76-82 CROSS STREET

**CITY OF PORTLAND, MAINE**  
**SITE PLAN REVIEW**  
**Processing Form**

Supplement to the Site Plan Review Processing Form for a 23 car parking lot at the corner of Spring Street and Cross Street - Michael Young developer.

MIKE'S PARKING
Scale 1/4" = 5'

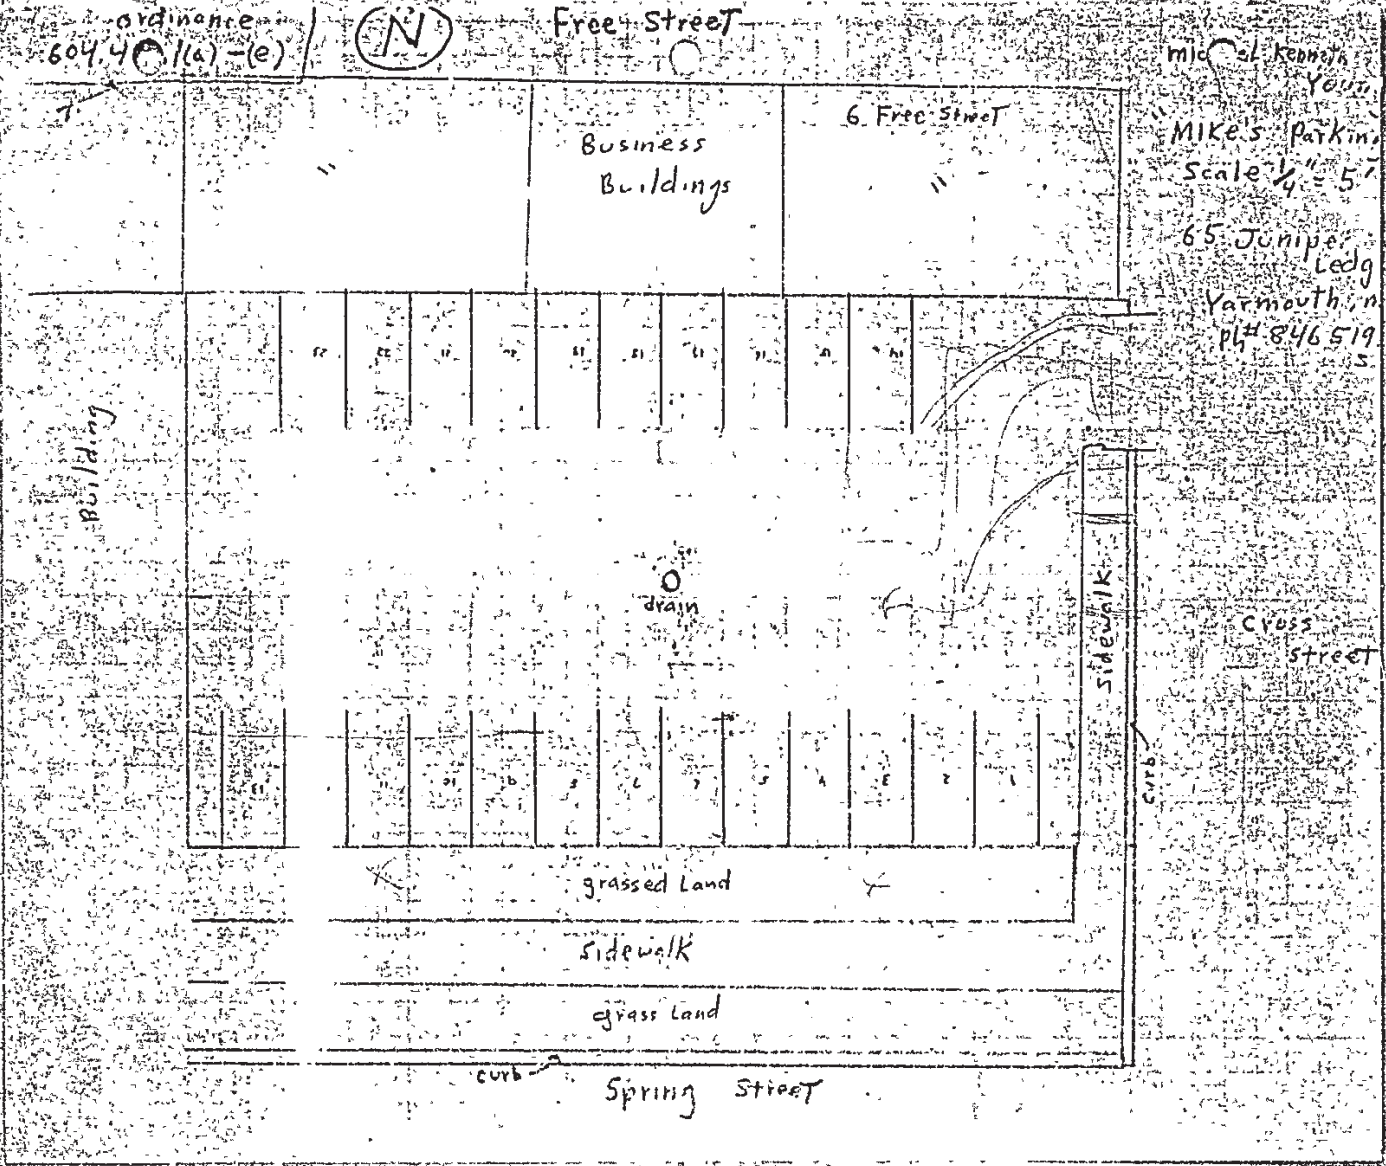
REASONS: ANY EXTERIOR LIGHTING TO BE APPROVED BY STAFF

In general, the plan as submitted is too deficient to make proper review. The areas of concern which remain unanswered are:

Access - Is the curb cut shown on the plan existing or proposed or both? Whether existing or not, the curb cut should be located in the center of the turning aisle between the two rows of parking stalls and should be at least 25 feet in width. This will allow for more proper vehicular movements to and from the site.

Lighting - Are there to be exterior lights installed. If so, lighting must meet the requirements of this Department as they pertain to intensity, height of support poles and type of the luminaire.

Drainage - Is the lot currently paved, if not, is it proposed to be paved. Is the "drain" shown on the plan an existing drain or a proposed drain.

If the lot is proposed to be paved and the drain is a proposed drain, this Department would require that the pavement area be reduced and that the developer create more "green areas" on site for which to control drainage on-site. This can easily be accomplished without affecting the proposed use of the site, and without the use of a storm drainage system which is a cost-saving factor to the developer and at the same time eliminates storm water run-off from our sewerage systems.

The Planning Department staff has not yet taken action on your site plan for a parking lot at Spring Street and Cross Street. The reason for the delay is that questions have been raised concerning access, drainage and screening, and I have been unable to reach you by telephone to arrange a meeting to resolve these questions. I believe that the staff's objections to the plan at this point are relatively minor and can be resolved at a meeting.
